REF: 22/03063/F

Location: Land East Of Larsen Road Heyford Park

16 October 2023

Preliminary Street lighting. Detailed design to be verified by Oxfordshire County Council's Street Lighting team.

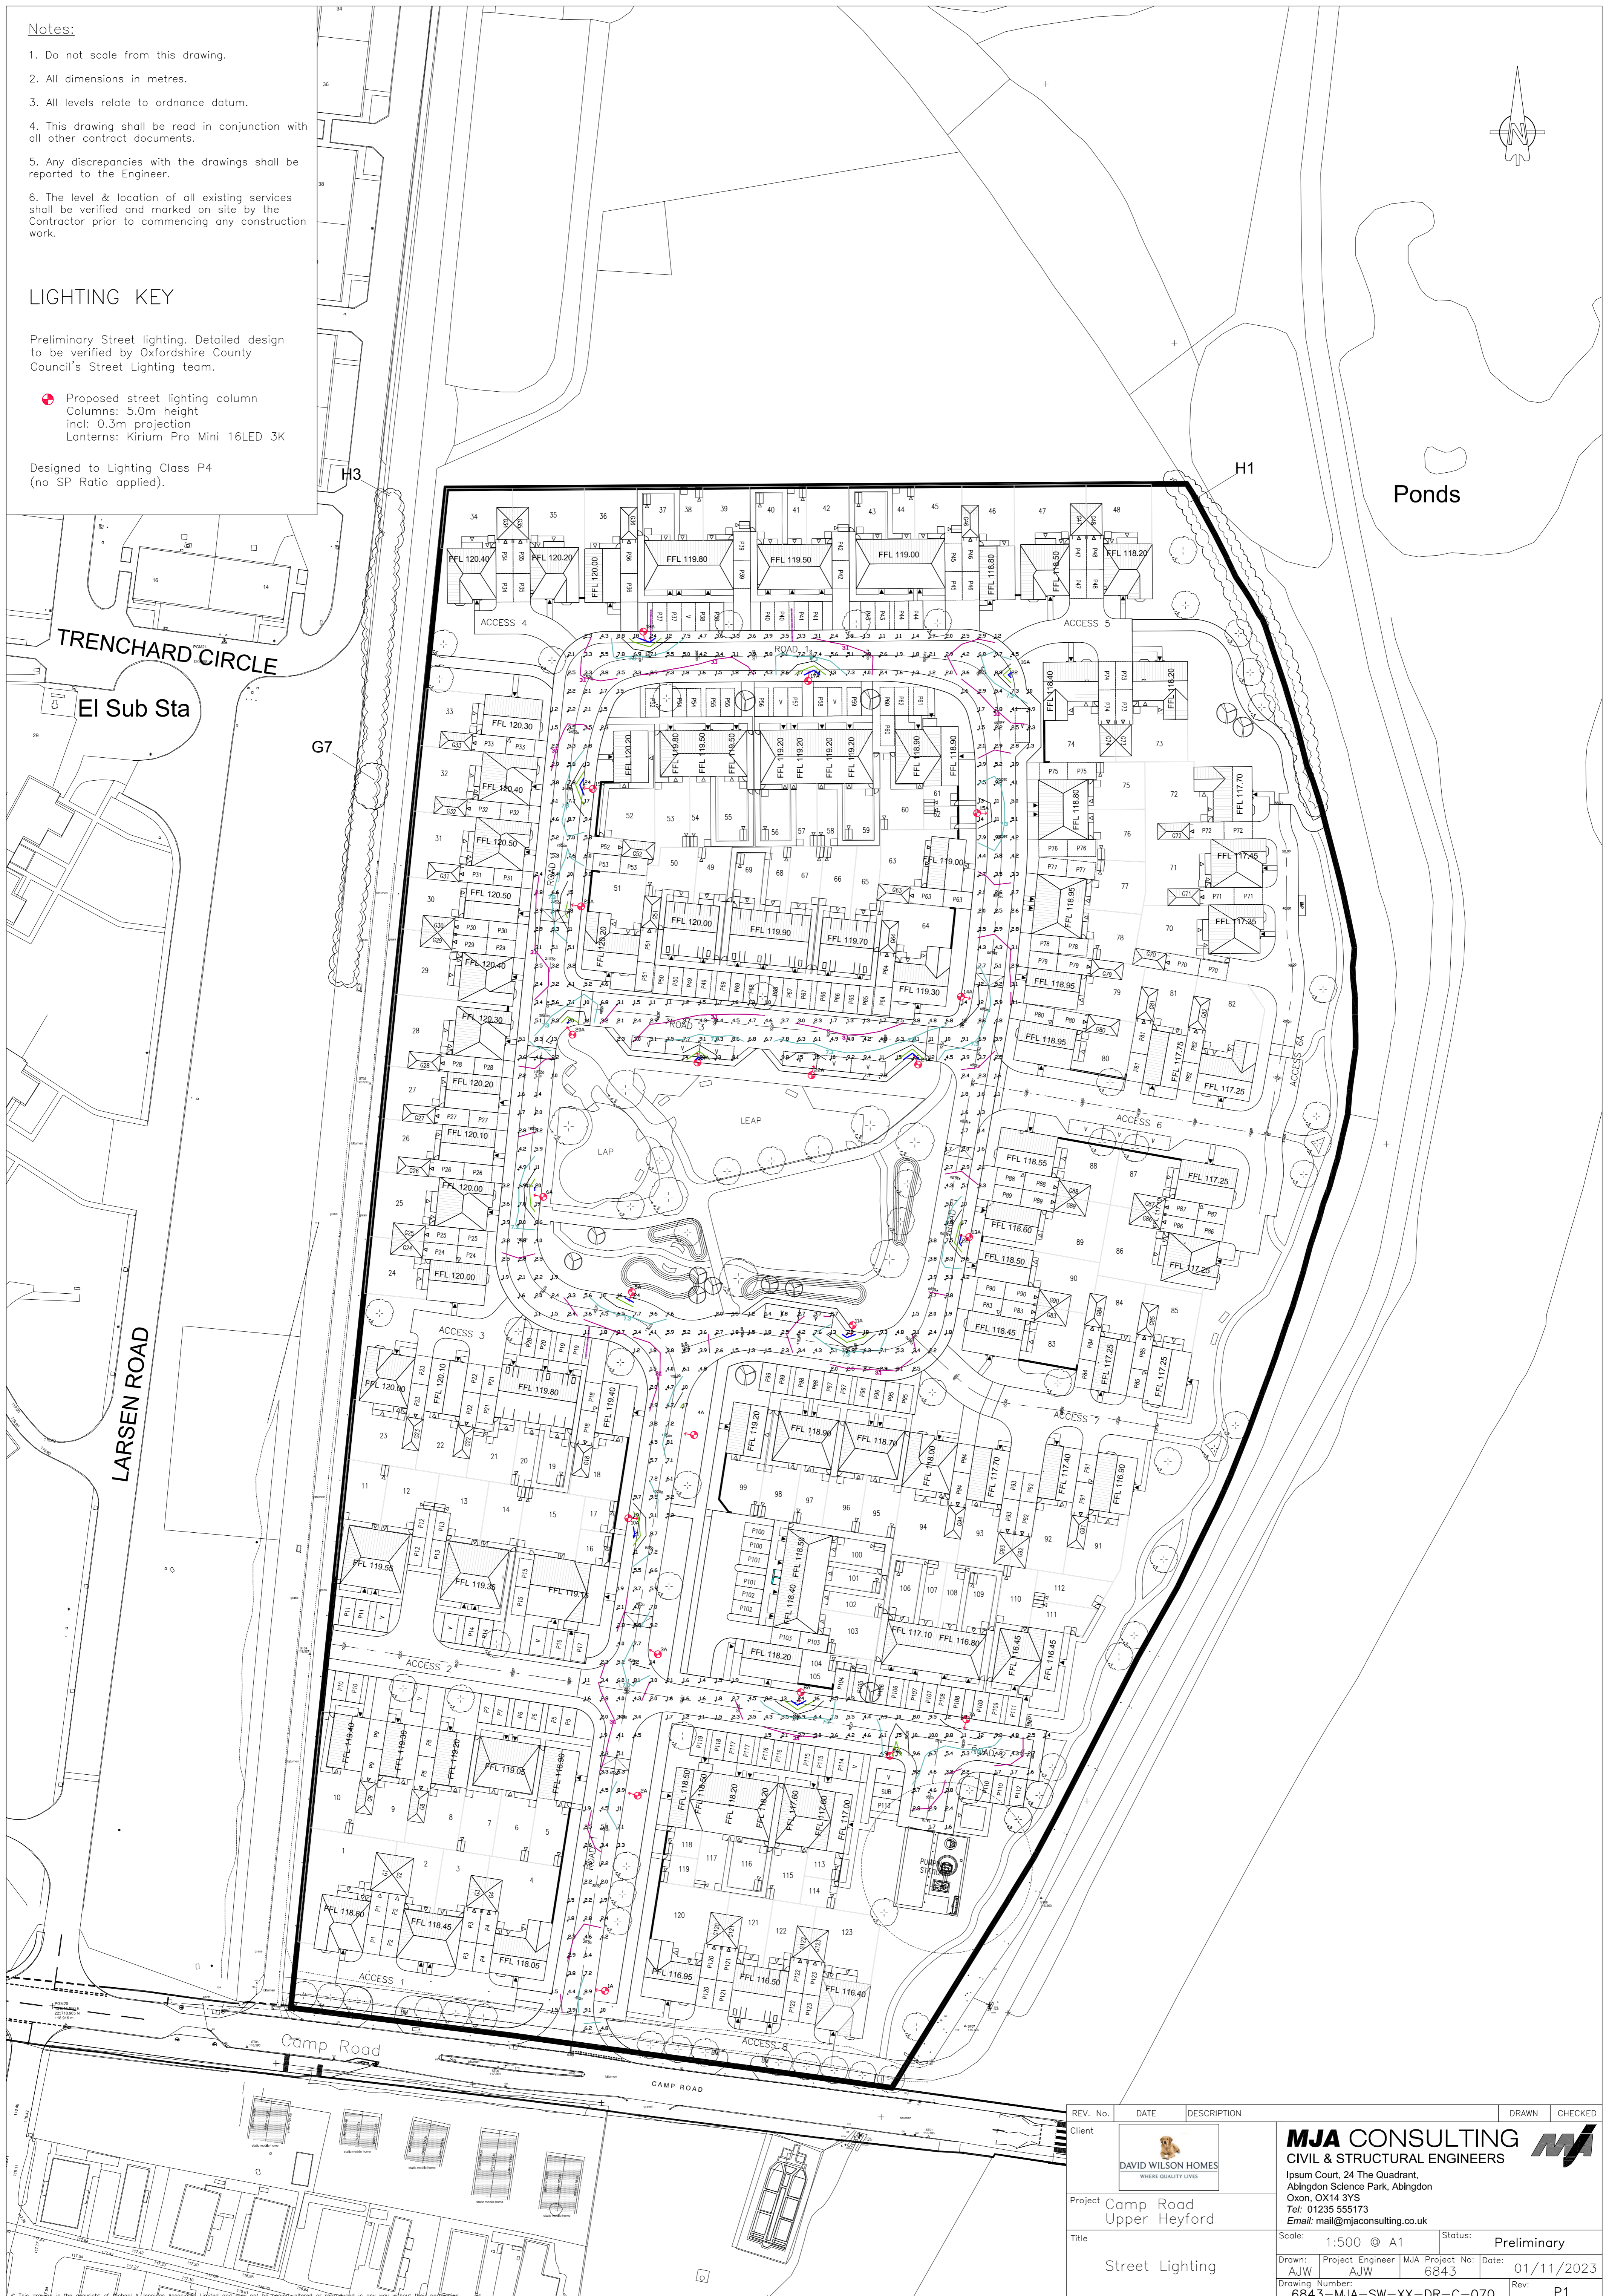
I am unable to locate any lighting plans within this application. Lighting throughout the development should meet the general standards of BS5489-1:2020. Lighting plans should be provided which should set out how this standard will be achieved not only on adopted highways, but also un-adopted roads and parking areas. Bollard lighting is not an appropriate lighting method, and should be avoided. Not only can they be damaged by reversing vehicles, more critically they do not provide sufficient light at the right height to aid facial recognition and reduce the fear of crime. It also does not deter crime and antisocial behaviour.

Residential dwellings should be provided with security lighting that provides illumination to the main entrance to the dwelling. PIR motion activated "on/off" lighting should not be used, and photoelectric "dusk till dawn" lighting should be used instead. PIR technology may be used to control dimming of the lighting when motion is not detected.

I ask that lighting plans should be provided prior to permission being granted. Alternatively, I ask that the following or similarly worded condition be placed upon the approval;

Prior to commencement of development, details of a proposed external lighting scheme shall be submitted to the local planning authority. The scheme shall set out the steps that will be taken to ensure that external lighting, including zonal/security lighting and column lighting within parking courts promotes a secure environment and does not cause a nuisance to local residents.
